Your ref: SSD-58601963
File no: MC-23-00007

**SSD-58601963 - Notification of exhibition of a State Significant Development
Application for Honeman Close Data Centre, Huntingwood**

Blacktown City Council's submissions to SSD-58601963

Figure 2: Location of the Conservation Area and the Landscape Buffer Zone

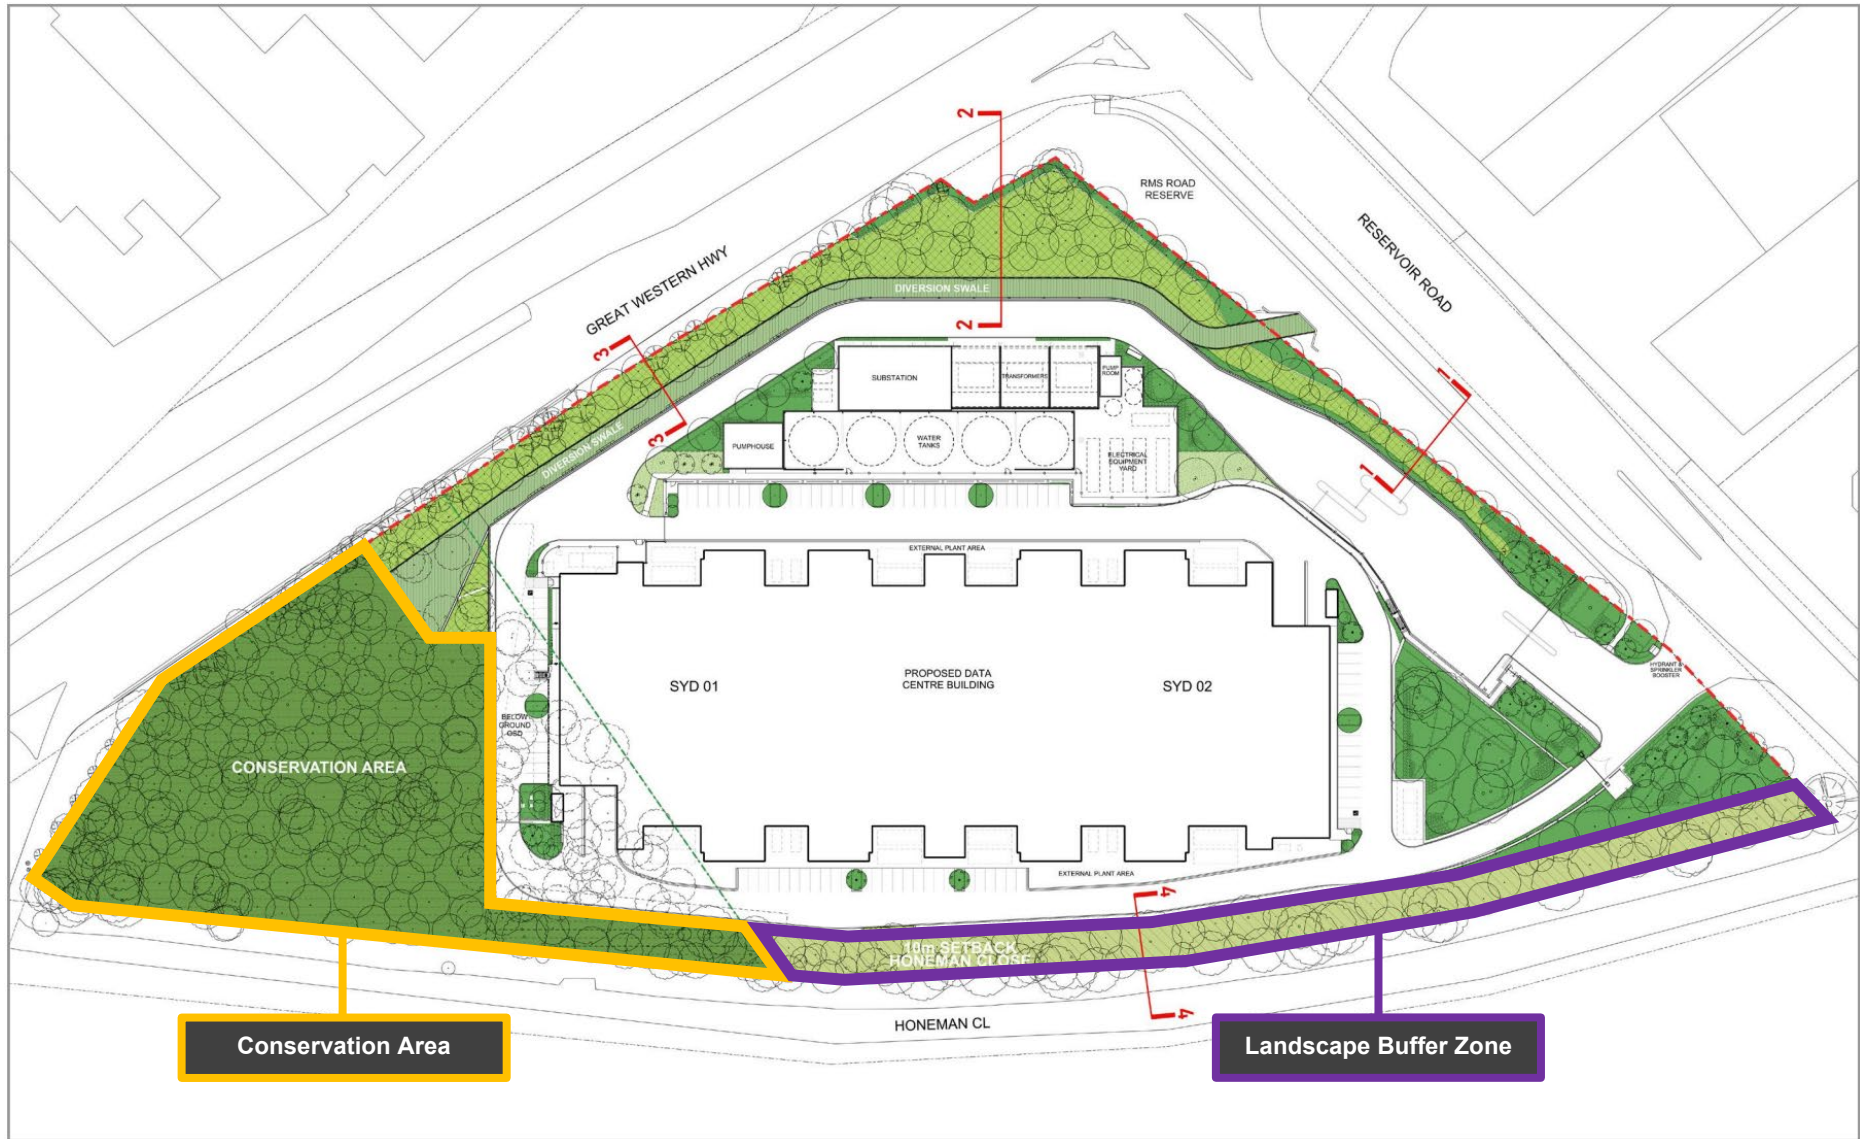
- b. No subdivision plan has been provided even though subdivision is proposed.
- c. Subdivision to have the conservation area on a separate lot from the lot upon which the data centre is proposed is not supported as the conservation area must be managed and maintained by the operator of the data centre in perpetuity and therefore form part of the same land parcel.

- c. It is strongly recommended that the proposed development be redesigned to retain the dimensions of the conservation area, as defined by the NSW Land and Environment Court, and all trees which occur within that area.

Figure 5 | Proposed site layout

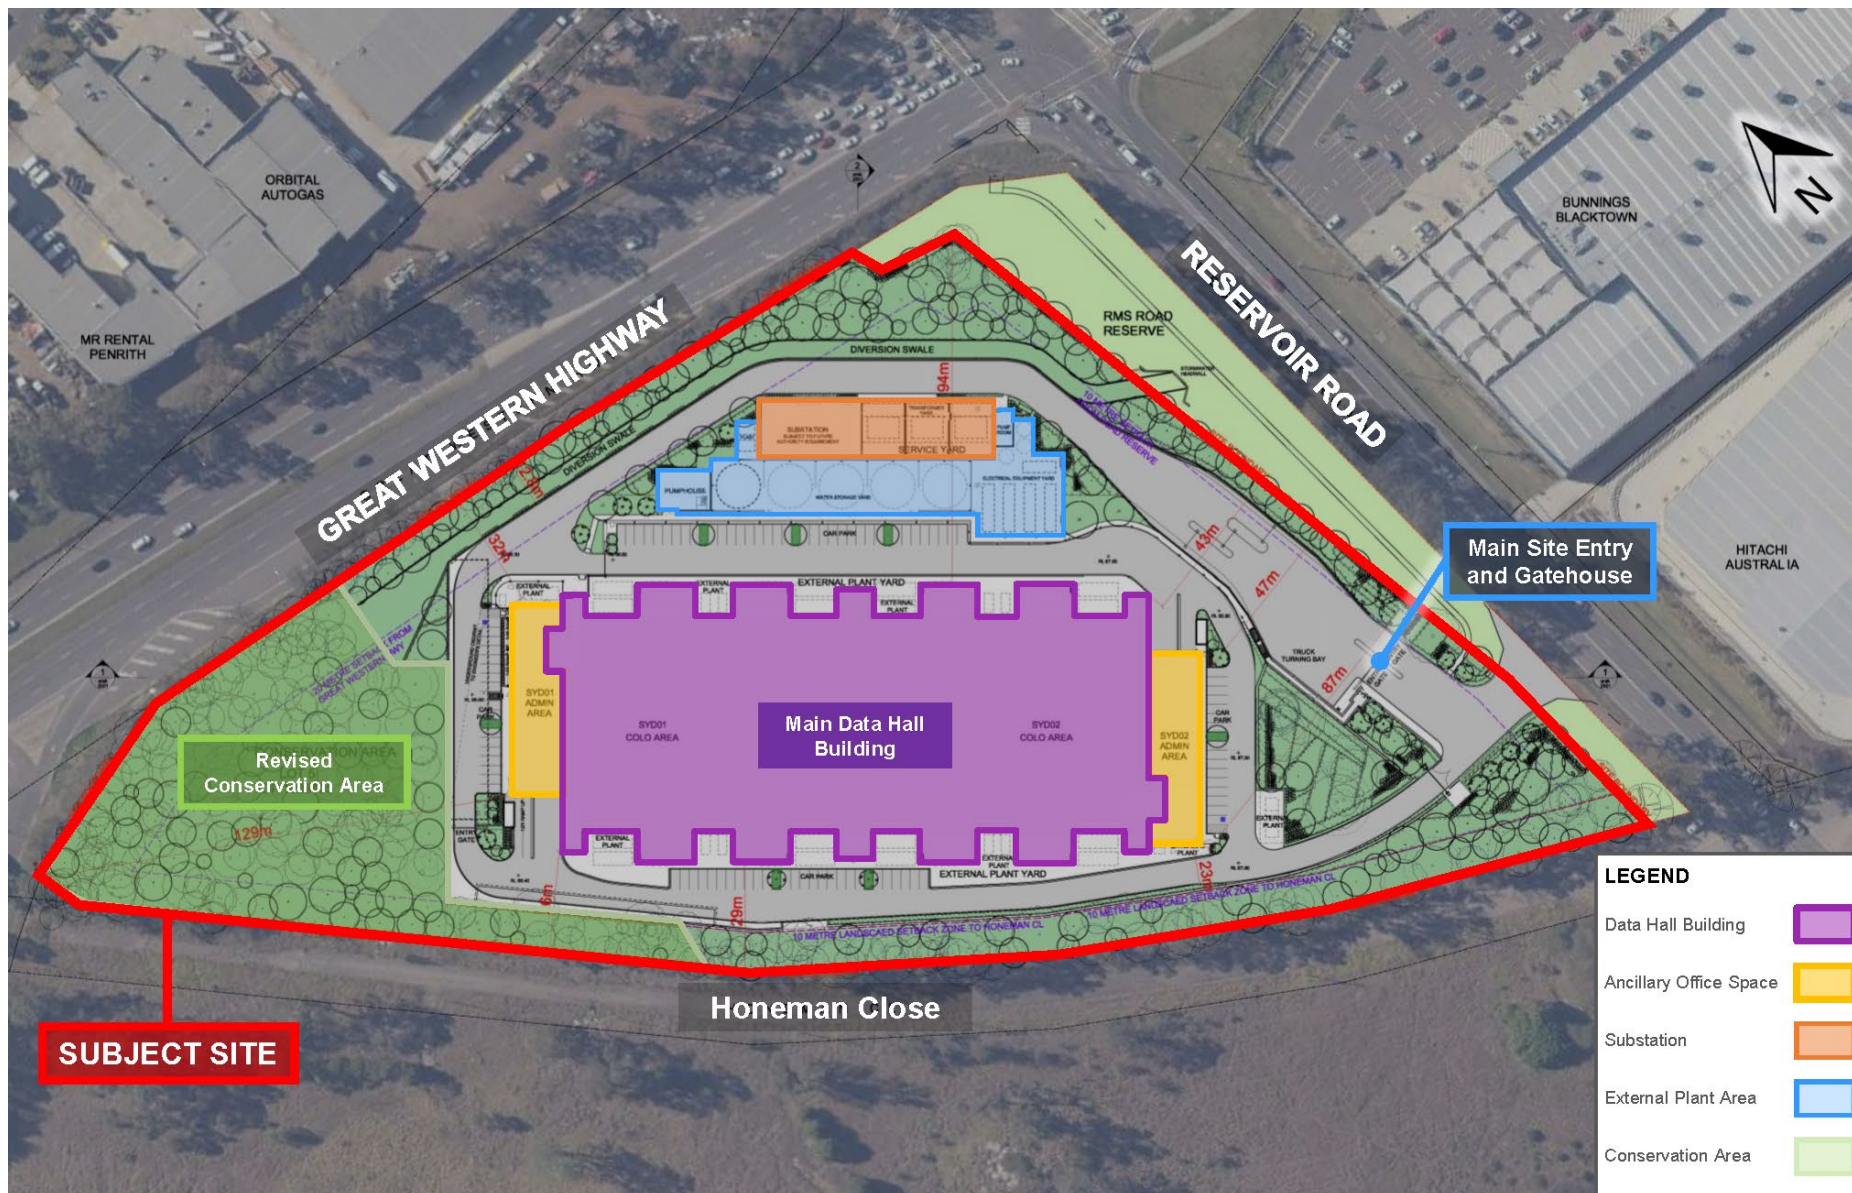
- e. The landscaping to Great Western Highway and Reservoir Road is massively reduced compared to the landscaping approved under DA-17-01780 as a result of the location of the internal loop road. The proposed internal loop road is also now located in the required 20m landscaped setback to Great Western Highway and even reduced the landscaping along the Reservoir Road to nothing. This a significant reduction in the landscaping approved under DA-17-01780 which is not supported. A fully landscaped 10 m setback is required to Reservoir Road behind the Transport for NSW road widening proposal and at least 10 m of the 20 m setback to Great Western Highway is to be fully landscaped.

- f. The proposal represents a massive parking non-compliance with the Huntingwood Development Control Plan which is not supported. It requires 225 parking spaces for the data hall component and 46 for the office component being a total of 271 spaces. Only 94 parking spaces are proposed being a shortfall of 177 parking spaces. The building's use could change at any time in the future to a use that demands full compliance with the parking rates.

- c. There is an internal road proposed within the 10 m wide setback from the road reserve to Reservoir Rd and the 20 m wide setback on the Great Western Highway sides. This is not supported.

Figure 12 | Location of potential Swift Parrot habitat in relation to the subject site

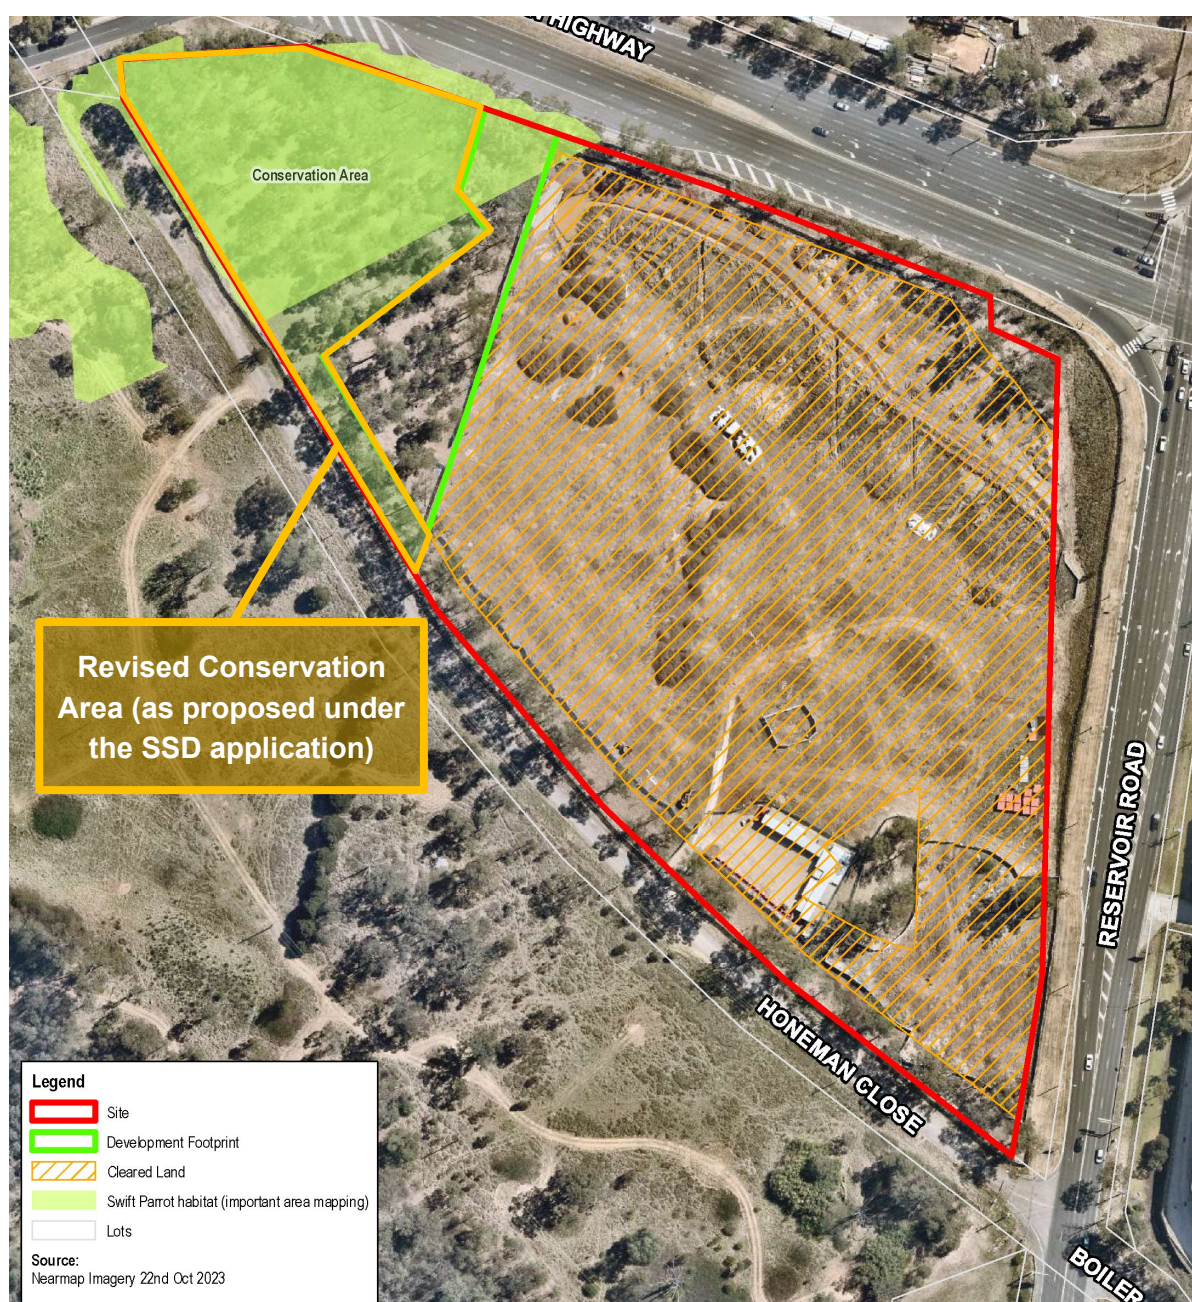
- e. Regarding the Biodiversity Development Assessment Report, Swift parrot should not be removed from candidate species credits for further assessment given the important habitat mapping for swift parrot on site. The map covers locations important for foraging/over-wintering for this Critically Endangered migratory species.
